Phone: 0300 123 6780
Email: developer@lancashire.gov.uk
Your ref: 3/2026/0446
Our ref: 3/2026/0446/HDC/KW
Date: 10 September 2026

Location: Ribble Valley View Old Langho Road Langho BB6 8AW
Proposal: Proposed erection of 9 no. holiday lodges.
Grid Ref: 370040 435875

Summary

No objection subject to conditions

Proposed Site Plan - Positions for lodges 1-9

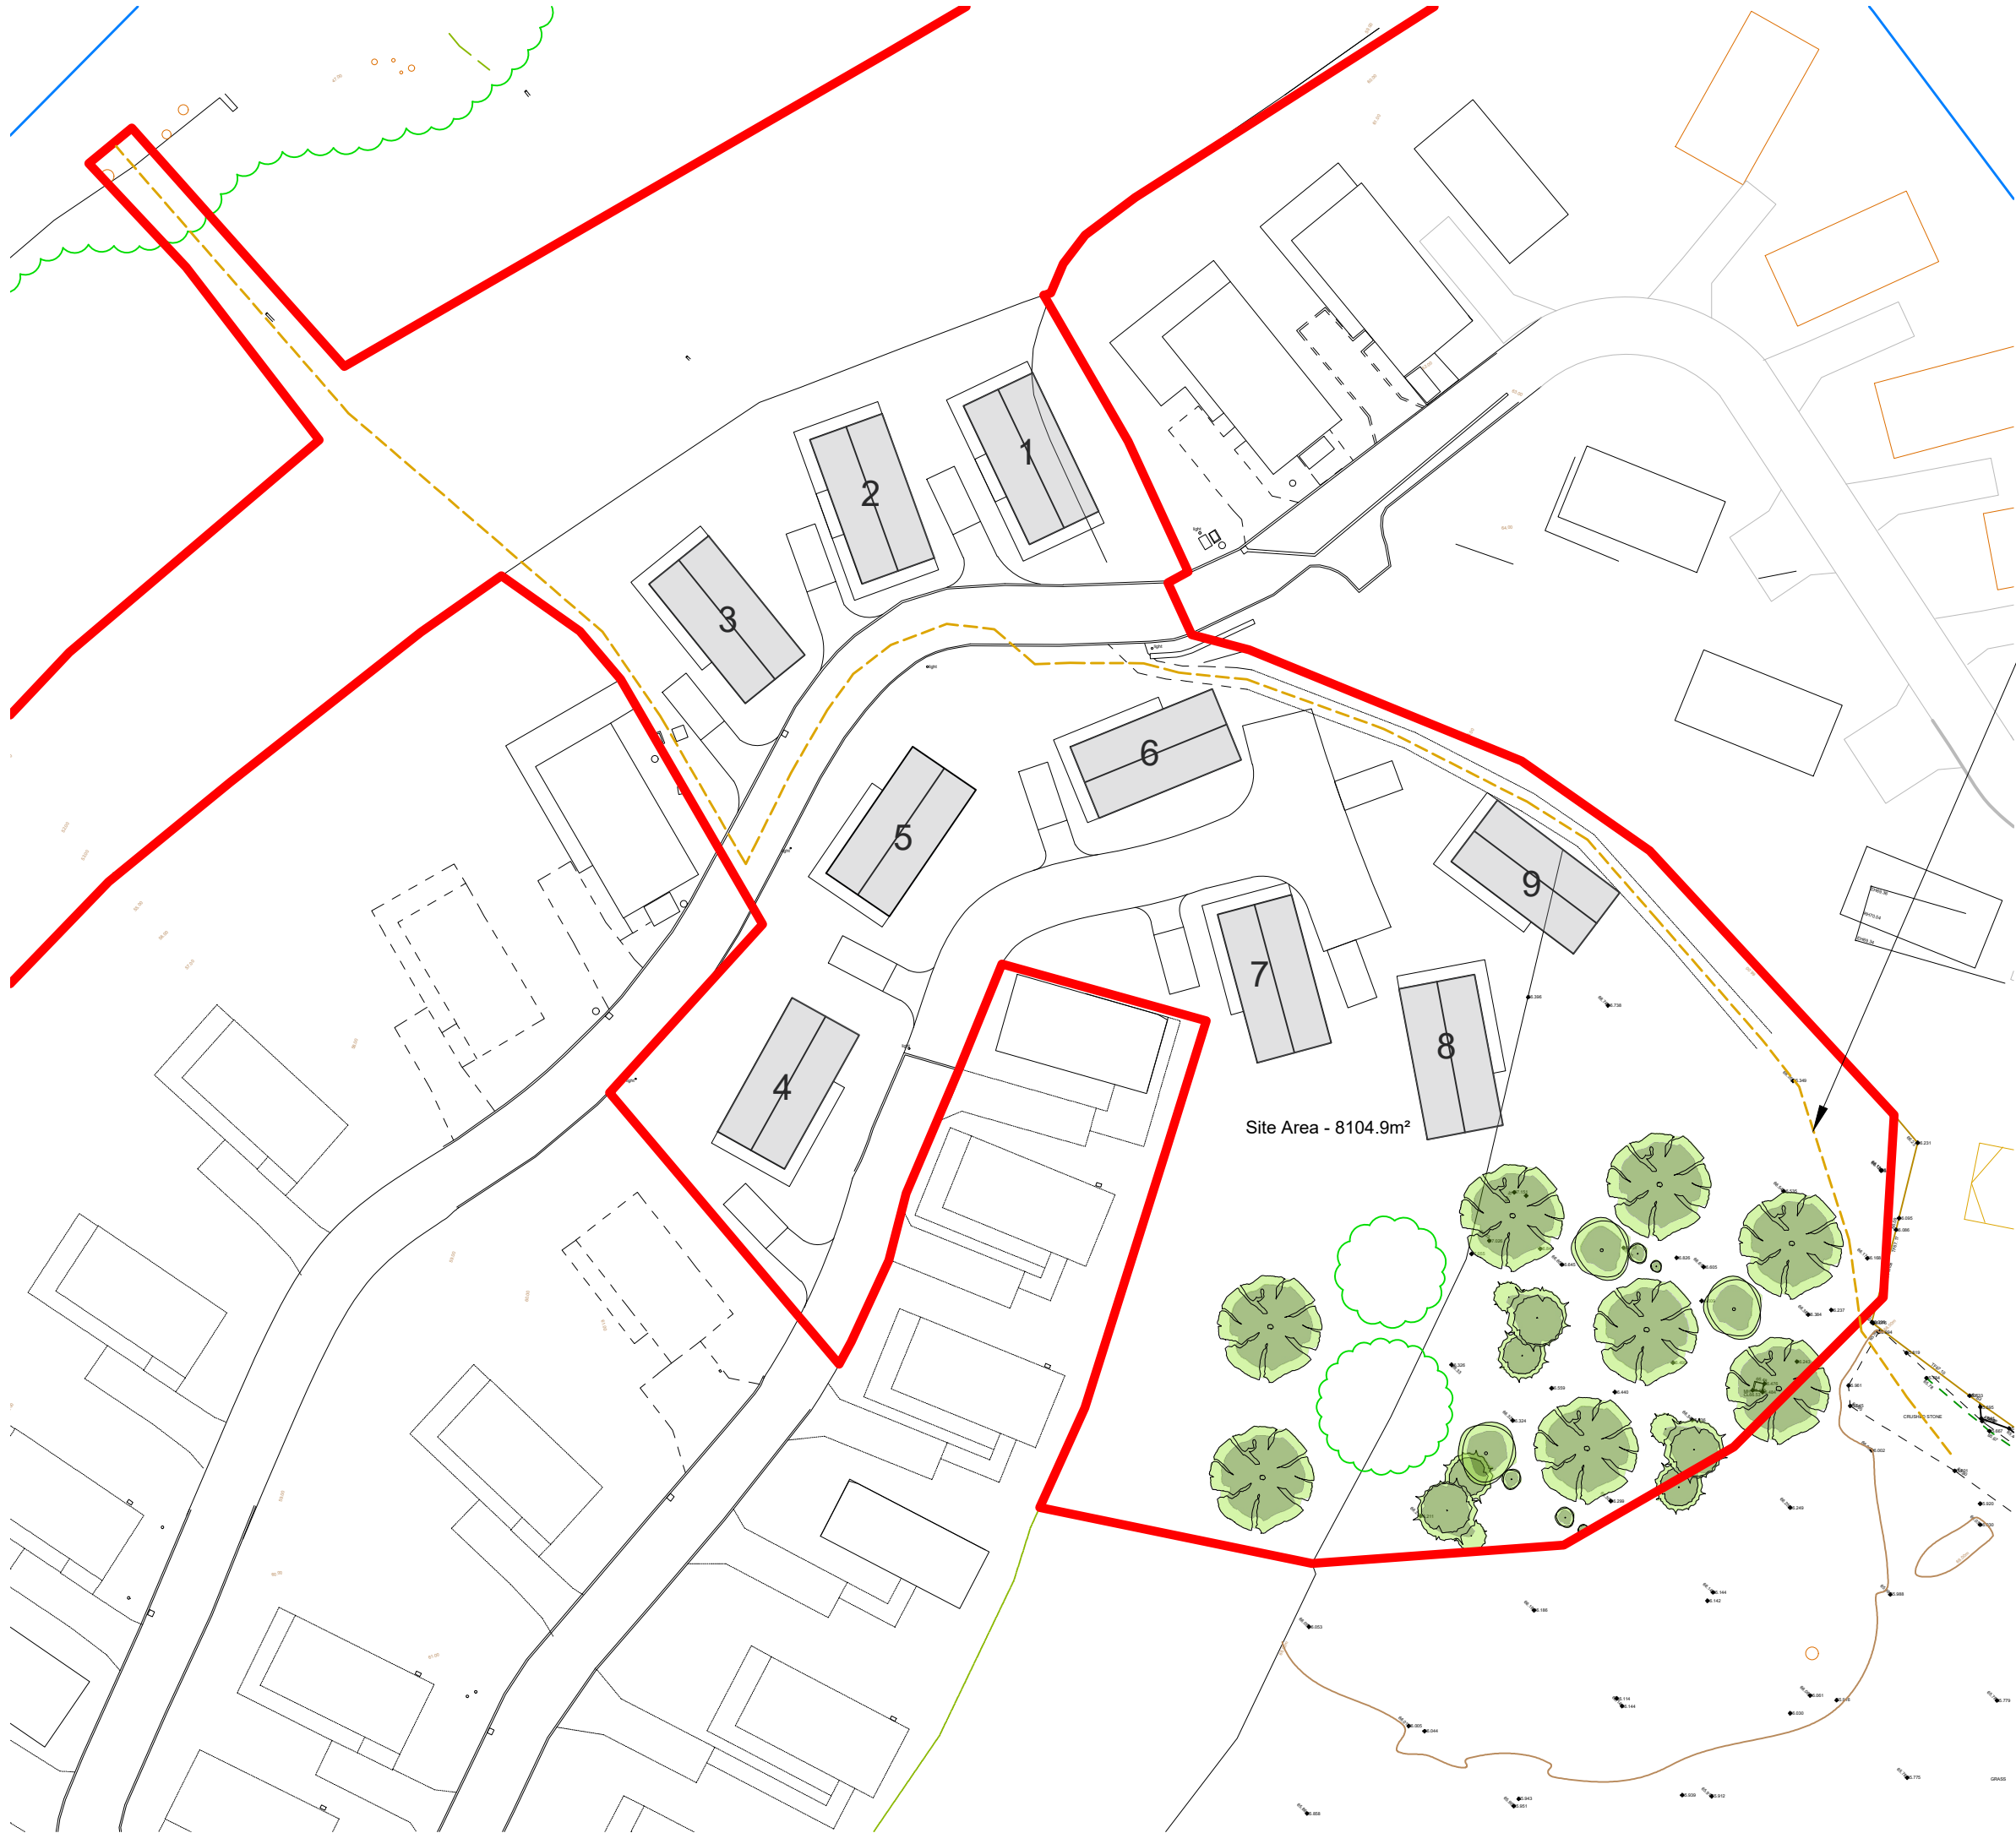
The LHA have reviewed the amended Proposed Site Plan and understand that plots 1 – 3 will be placed adjacent to the existing internal road and a new internal road is proposed within the site which will provide access to plots 4 - 9. The width of the internal layout will remain similar to what already exists within the site, and a turning head is provided where the access road comes to an end. The drawing shows that a minimum of two car parking spaces for each holiday lodge will be provided at the site, which is acceptable given the nature of the site.

Public Footpath FP0306005 runs through the proposed development and continues northward to a footbridge over Dinkley Brook. The granting of planning permission does not constitute the diversion of a Definitive Right of Way. The Applicant will have to apply for a Diversion Order to make the diversion of the PROW a permanent feature at the site. The Diversion Order will have to be certified and in place before works can commence. The applicant should be advised to contact Lancashire County Council's Public Rights of Way section by email on PROW@lancashire.gov.uk, quoting the location, district and planning application number, to discuss their proposal before any development works begin.

The applicant must be certain that they have private vehicular rights along this public path before driving on it either during construction or for subsequent access. Without private vehicular rights or permission from the owner it is a criminal offence to drive a motor vehicle on the public path.
